Rezoning Transportation Analysis

Petition Number: 2023-091

Date	Description
9-28-23	First Review (NK)

SCHEMATIC SITE PLAN

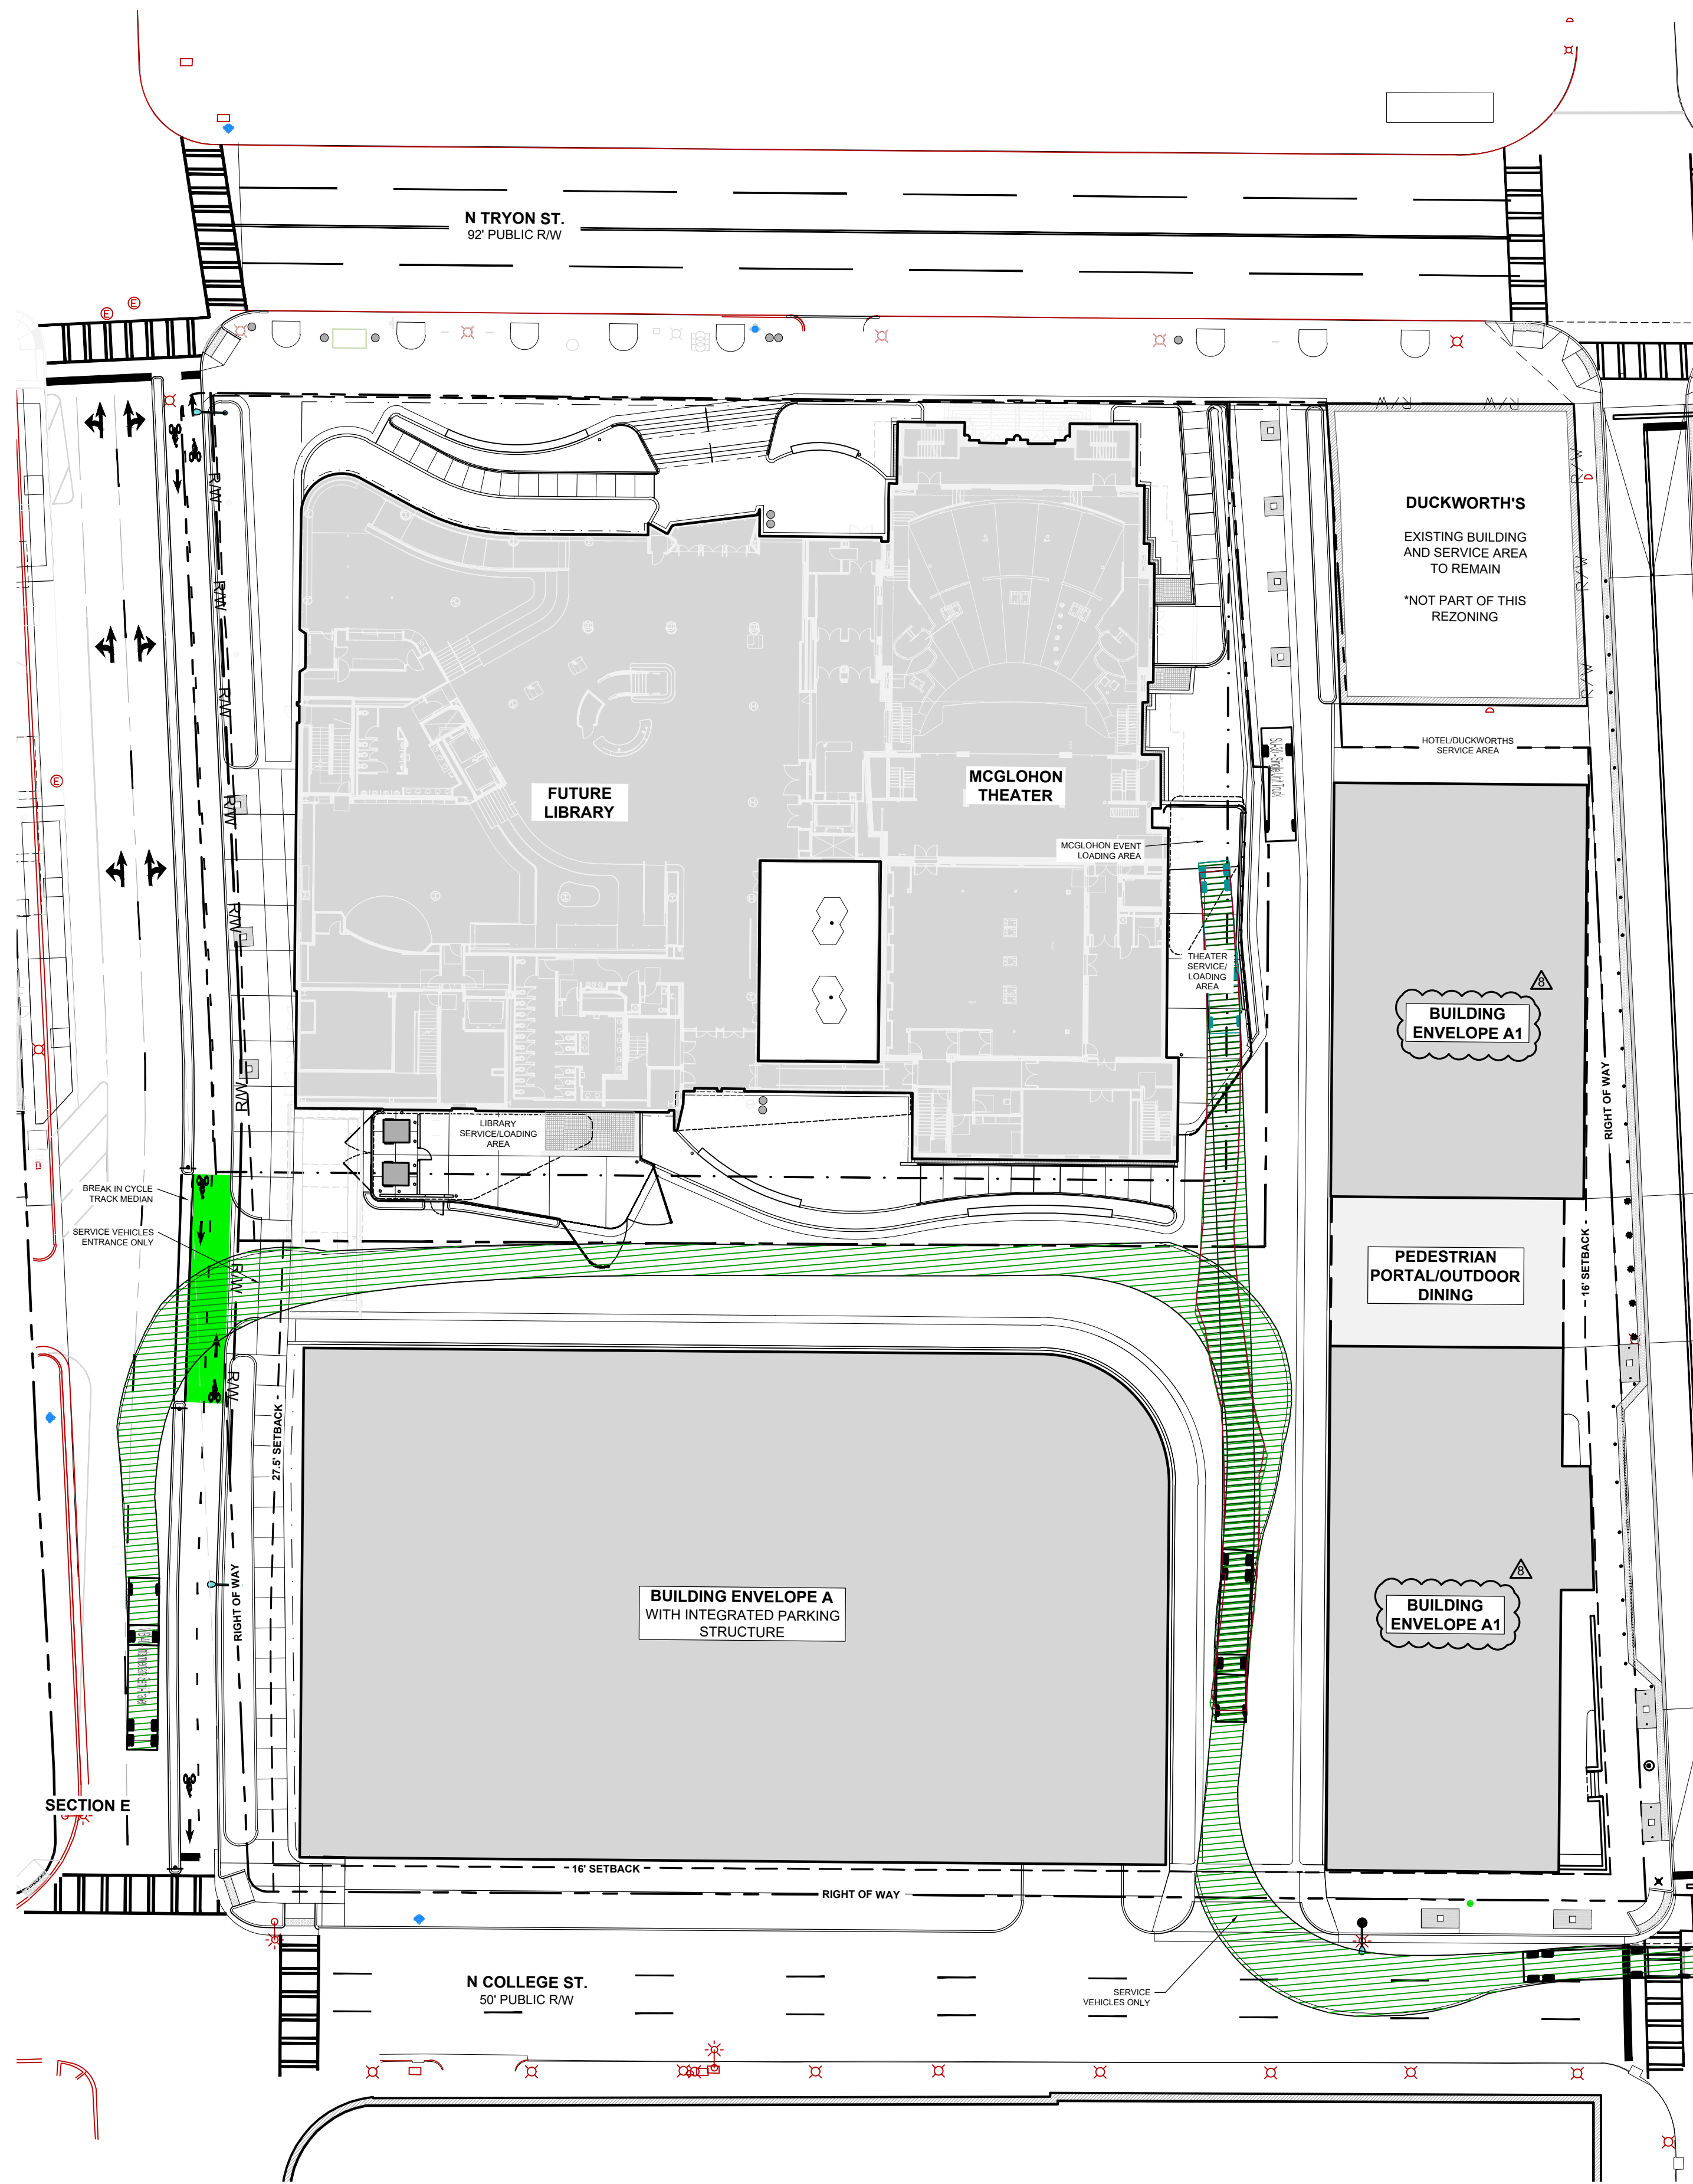
3. Revise site plan and conditional note(s) to commit to dedicate right-of-way from the road centerline to 2' behind the shared use path. The site plan shall label and dimension the right-of-way from the road centerline.

6. Per City of Charlotte Sight Distance Policy and Charlotte UDO, 10' x 10' pedestrian sight triangles will be required at all connections to the public roadway system.
